Rollin Ridge Commercial, PUD-18-003, (Revised 09June2018)

Please accept the following revised comments from El Paso County Public Health regarding the proposed commercial development:

**WELL & SEPTIC LOCATION PLAN
PUD DEVELOPMENT PLANS
ROLLIN RIDGE ESTATES COMMERCIAL CENTER**

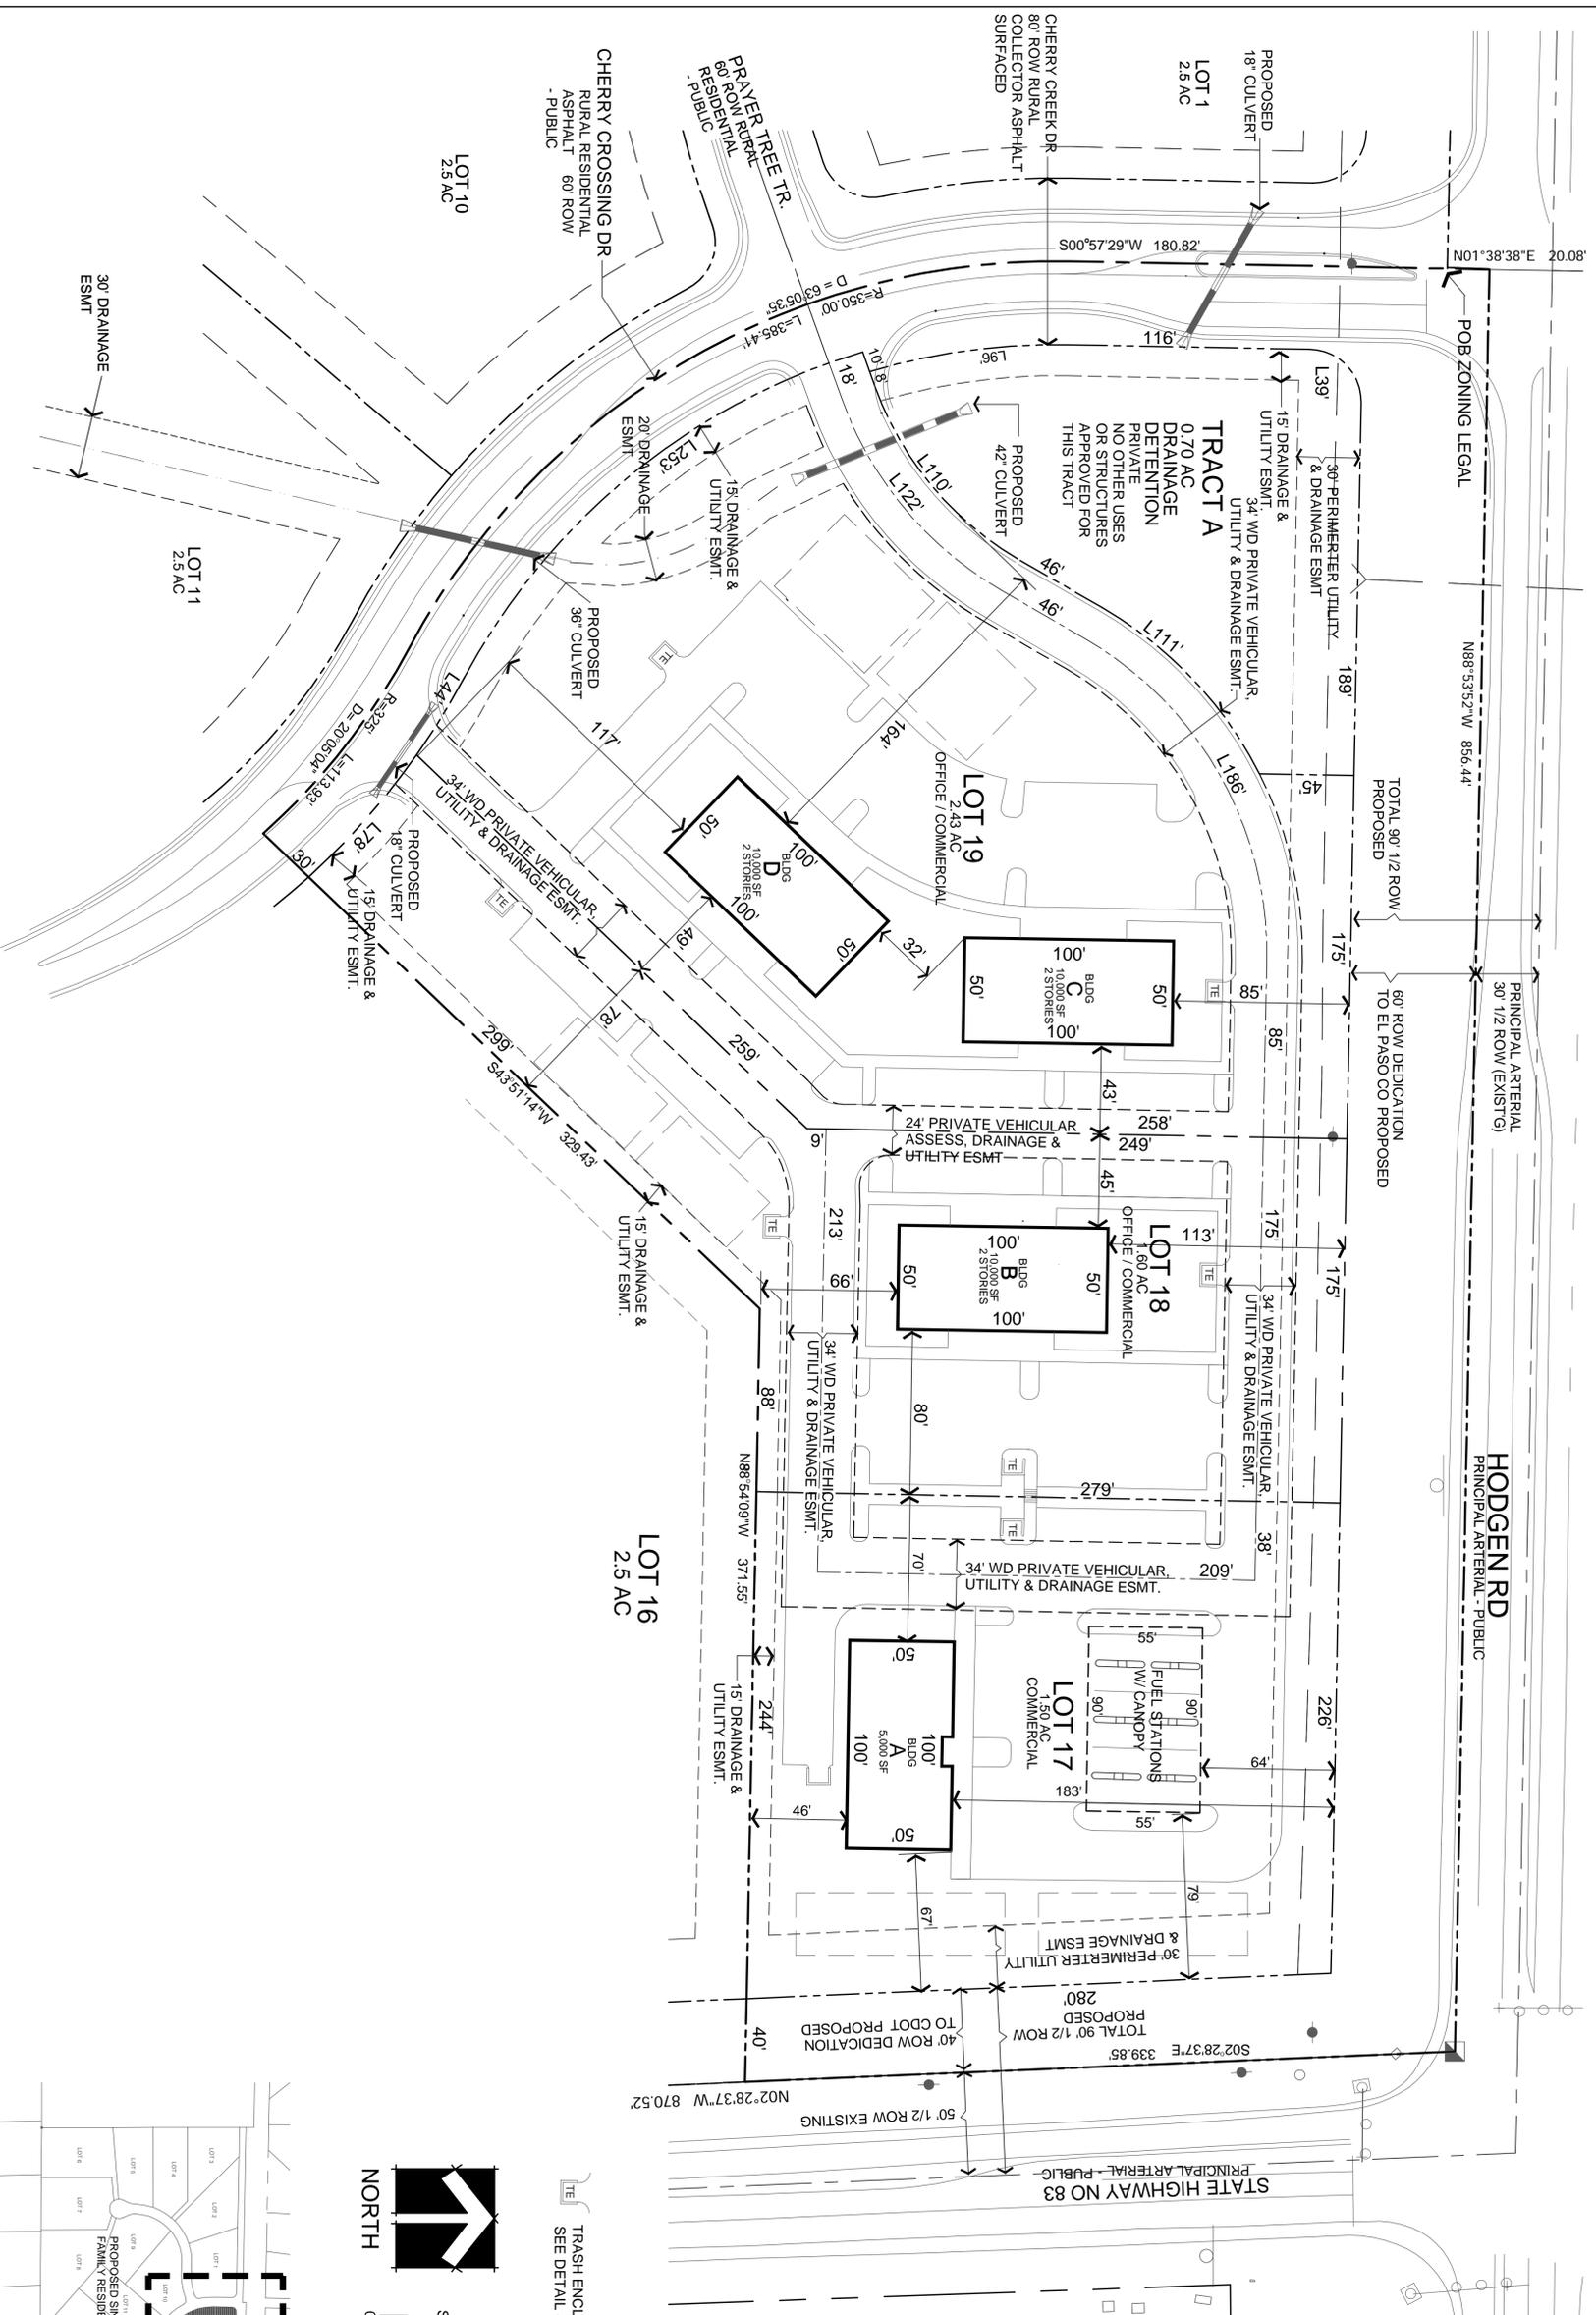
- **The primary and secondary soil treatment areas identified in Tract B must be protected from compaction during all development and construction processes. Severe damage to these areas may cause further limitations to the scope of the commercial development of Tract B.**

- **The 24Nov2017 Entech Engineering, Inc., Soil, Geology, Geologic Hazard, and Wastewater Study reported that the majority of OWTS's on the site will require a professional engineer design due to shallow bedrock and poor soils. All commercial development shall have onsite**

wastewater treatment systems designed by a Colorado Registered Professional Engineer.
